August 24, 2020

**Re: Beyond Health Office Building**  
**3700 Bosque Plaza Lane NW**  
**Traffic Circulation Layout**  
Architect's Stamp 08-19-2020 (E12-D006H)

Based upon the information provided in your submittal received 08-20-2020, the above referenced plan cannot be approved for Building Permit until the following comments are addressed:

Sheet No.  
**AS101**

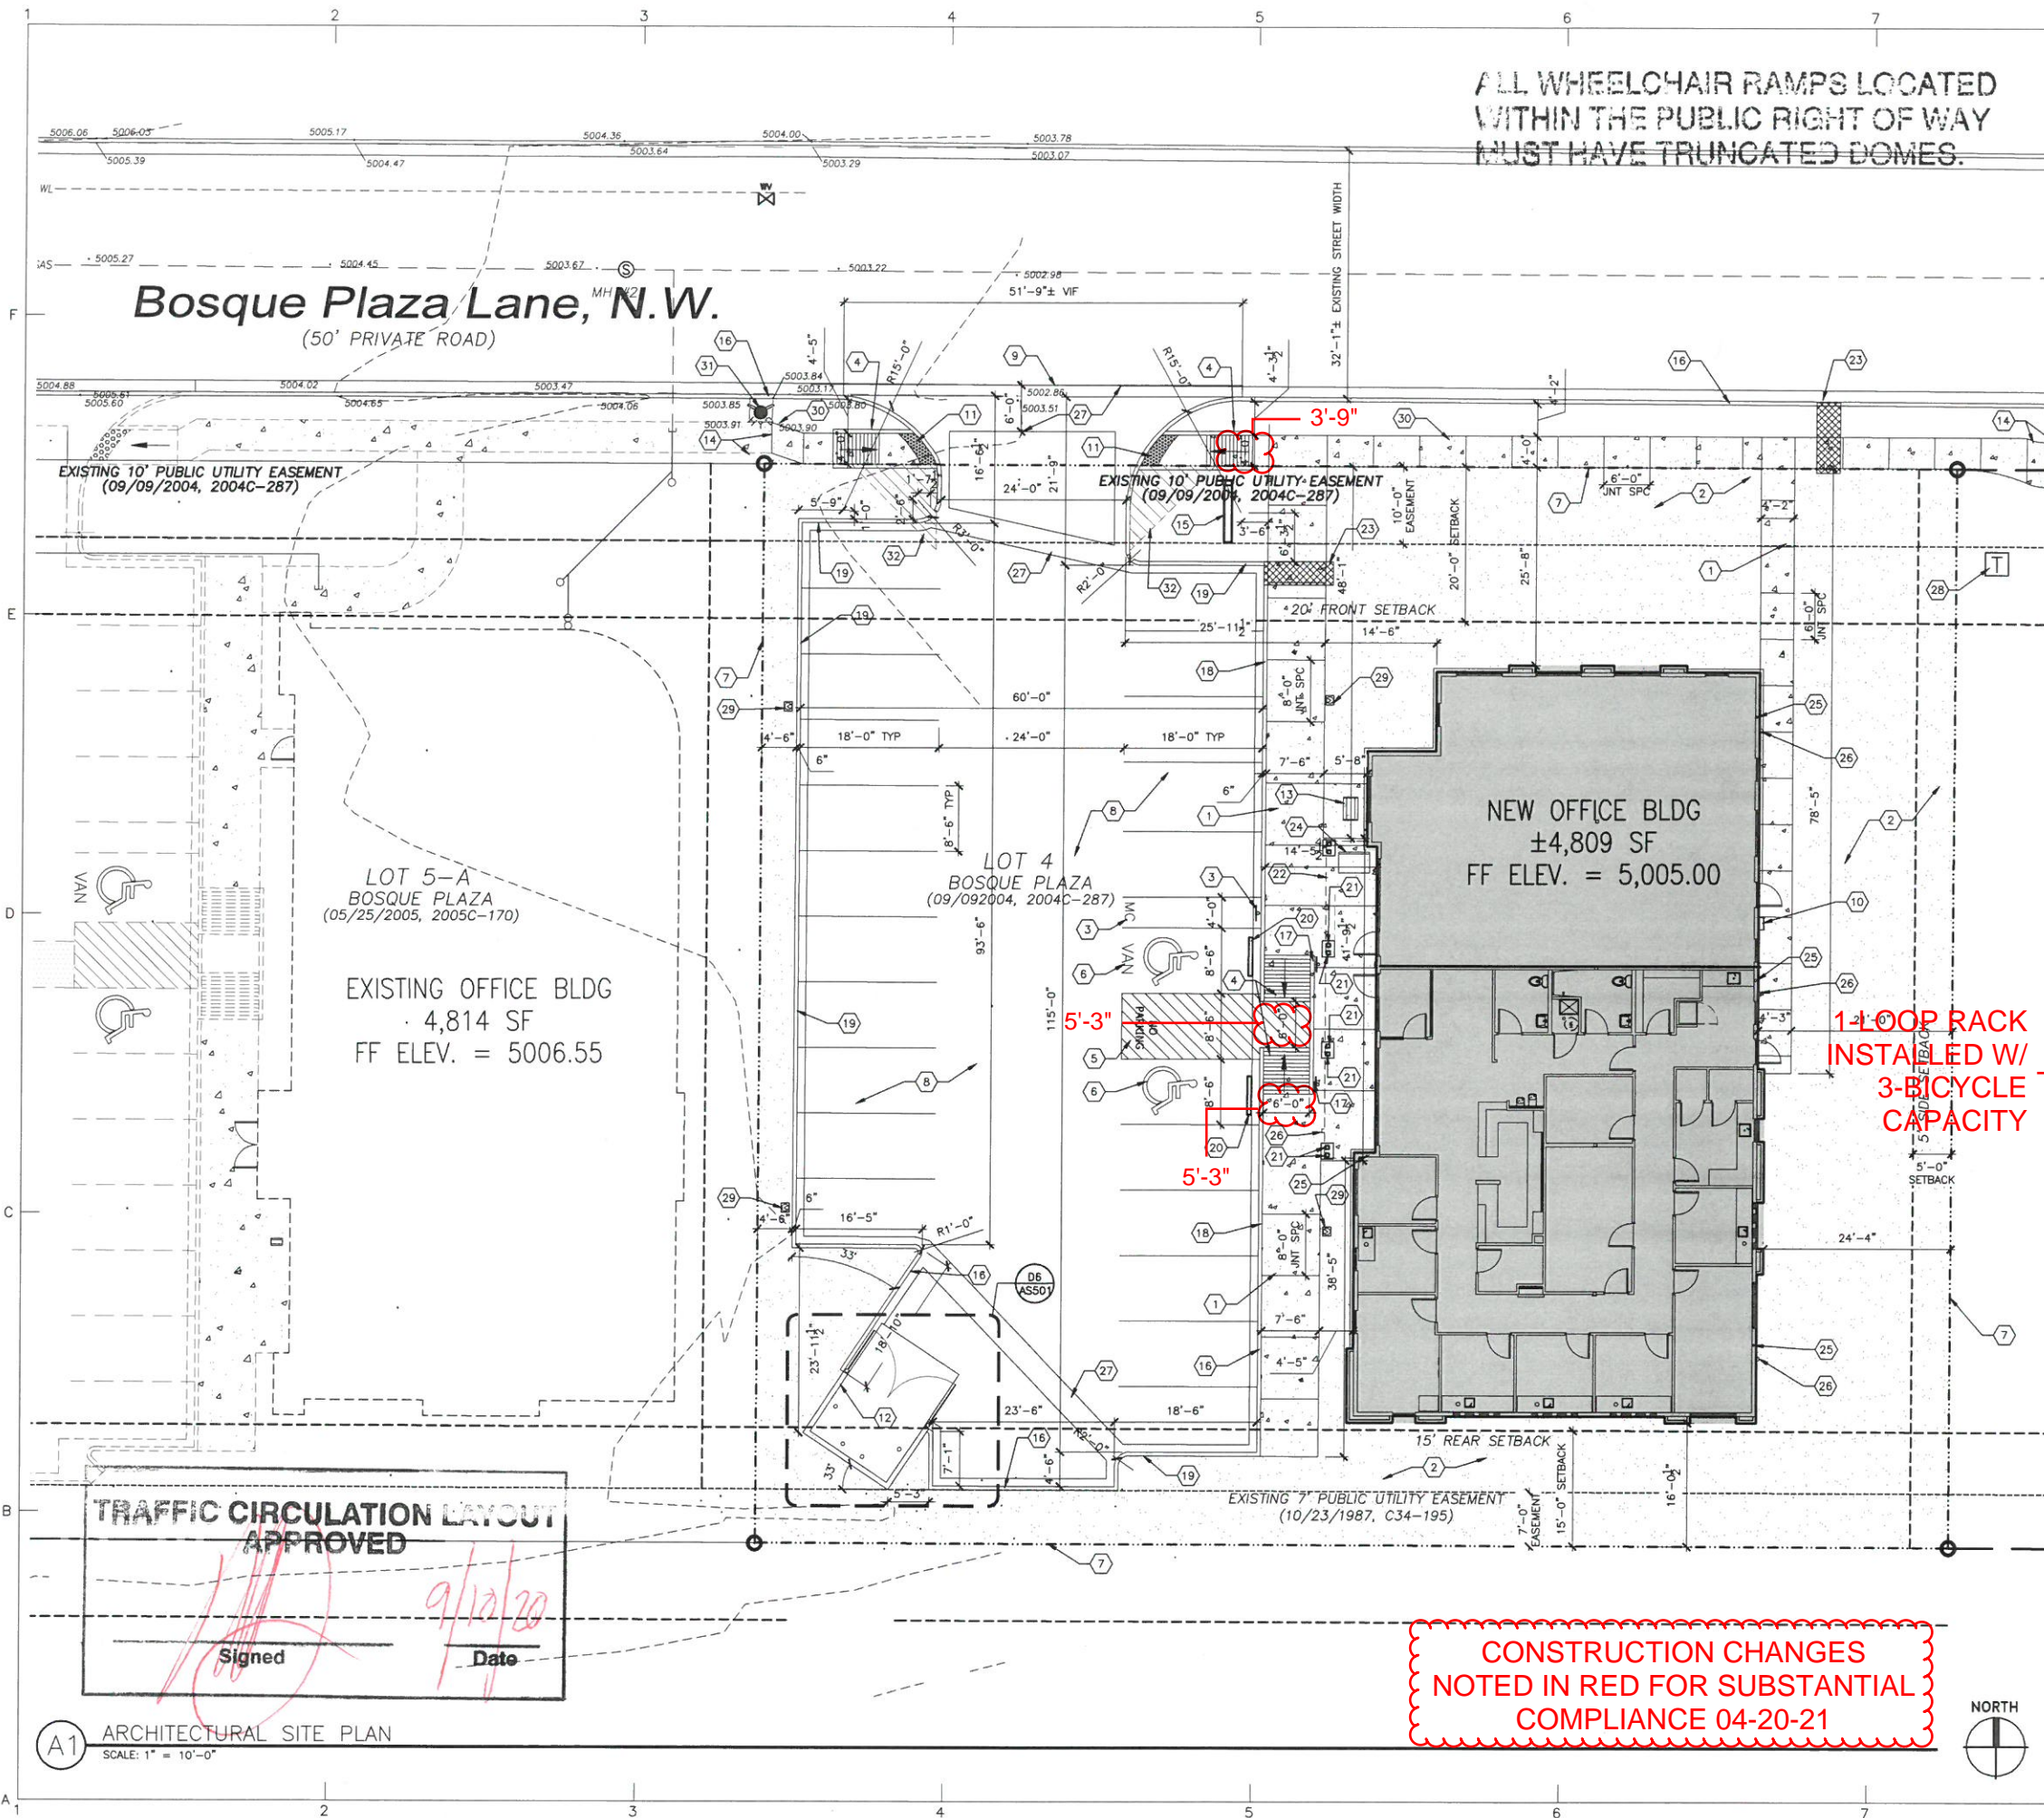
1. Please show a vicinity map showing the location of the development in relation to streets and well known landmarks.
2. List the number of parking spaces required by the zoning code as well as the proposed number of parking spaces including bicycle and motorcycle parking. All proposed required calculations need to be coordinated with Zoning.

5. All proposed sidewalk needs to be located at property line. Reflect this condition on site plan.
6. West end of proposed public sidewalk will need a transition around hydrant, please call out COA std dwg 2432 and show the transition on Site Plan. East end of development sidewalk connection needs to be shown.

7. The proposed 24 ft entrance (COA std dwg 2426-label) needs to be called out with 6 ft valley gutter (2420) and ADA wheel ramps.
8. Bosque Plaza Lane proposed public sidewalk: Label all proposed 4 ft public sidewalk per COA std dwg 2430.

9. The proposed Monument Sign needs to be located on private property. This includes the air space.
10. Paint proposed bollards yellow.
11. The minimum parking stall dimensions are:

12. Motorcycle parking spaces shall be designated by its own conspicuously posted upright sign, either free-standing or wall mounted per the zoning code. Label pavement MC.

14. Bicycle racks shall be sturdy and anchored to a concrete pad.
15. A 1-foot clear zone around the bicycle parking stall shall be provided.
16. Bicycle parking spaces shall be at least 6 feet long and 2 feet wide.

17. List radii for all curves shown; for passenger vehicles. **Radius for delivery trucks, fire trucks, etc. is 25 ft. or larger.**
18. Per the IDO, a **6 ft. wide** ADA accessible pedestrian pathway is required from the public sidewalk to the building entrances. Please clearly show this pathway and provide details.

20. Parking areas shall have barriers to prevent vehicles from extending over **sidewalk**, public right-of-way, or abutting lots.
21. Provide a copy of refuse approval.

23. Show the clear sight triangle and add the following note to the plan:  
"Landscaping and signage will not interfere with clear sight requirements.  
Therefore, signs, walls, trees, and shrubbery between 3 and 8 feet tall (as  
measured from the gutter pan) will not be acceptable in the clear sight triangle.
